Response to Planning application from Hertfordshire County Council (T and CP GDP Order 2015)

District ref: 6/2021/3462/ADV
HCC ref: WH/10313/2021
HCC received: 20 December 2021
Area manager: Matthew Armstrong
Case officer: Paul Marshall

COMET HOTEL ST ALBANS ROAD WEST HATFIELD AL10 9RH

Installation of 1 x non-illuminated sign on front elevation and relocation of existing signage from ground floor to first floor level

NEW SIGN DETAILS - Face Illuminated 'Element Bar & Kitchen'

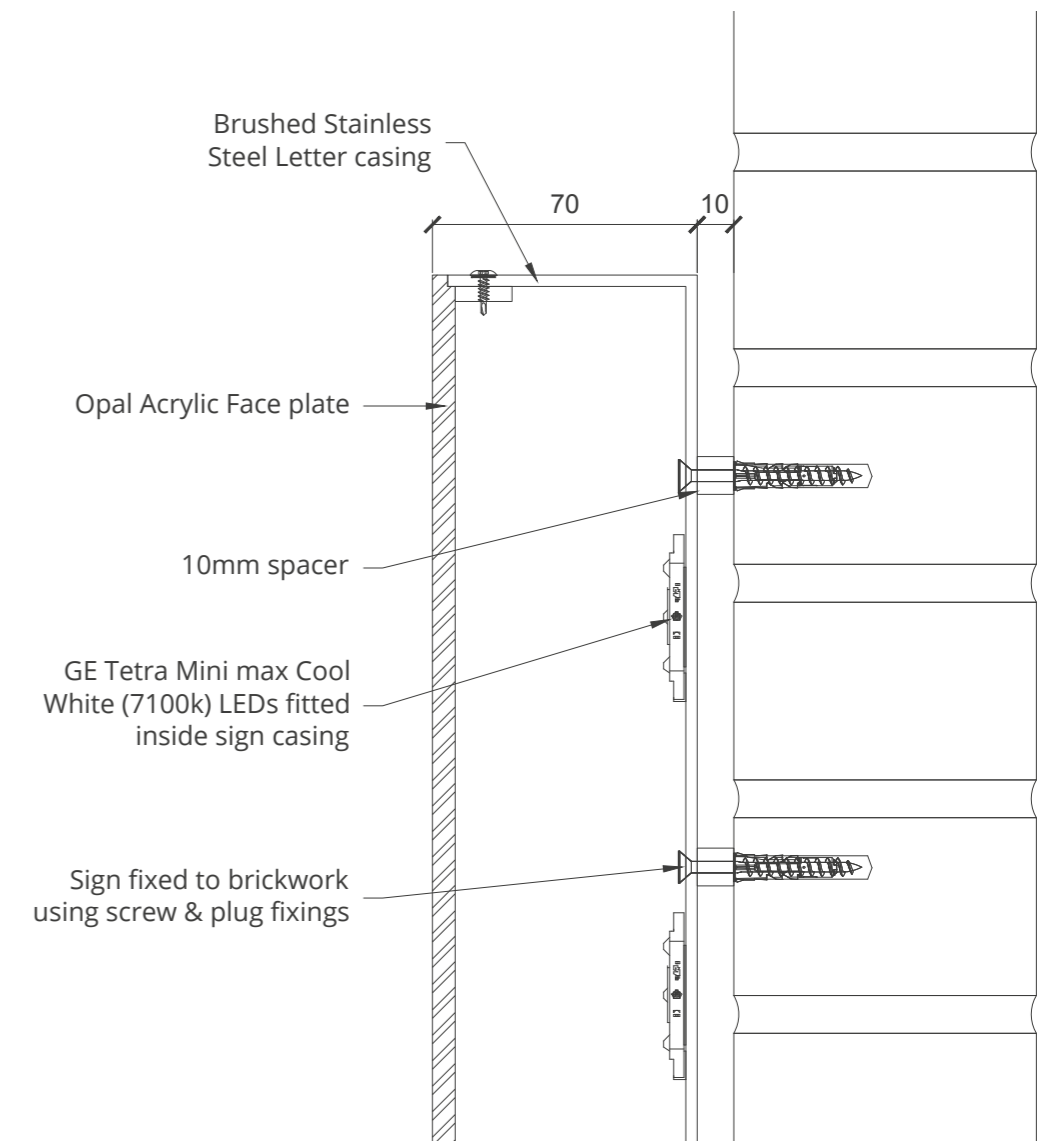
CON1) Prior to the first use of the development hereby permitted the intensity of illumination shall be controlled at a level that is within the limit recommended by the Institution of Lighting Professionals in the publication 'Technical Report No 5: Brightness of Illuminated Advertisements' and 'Guidance Notes for the Reduction of Obtrusive Light GN01:2014'.
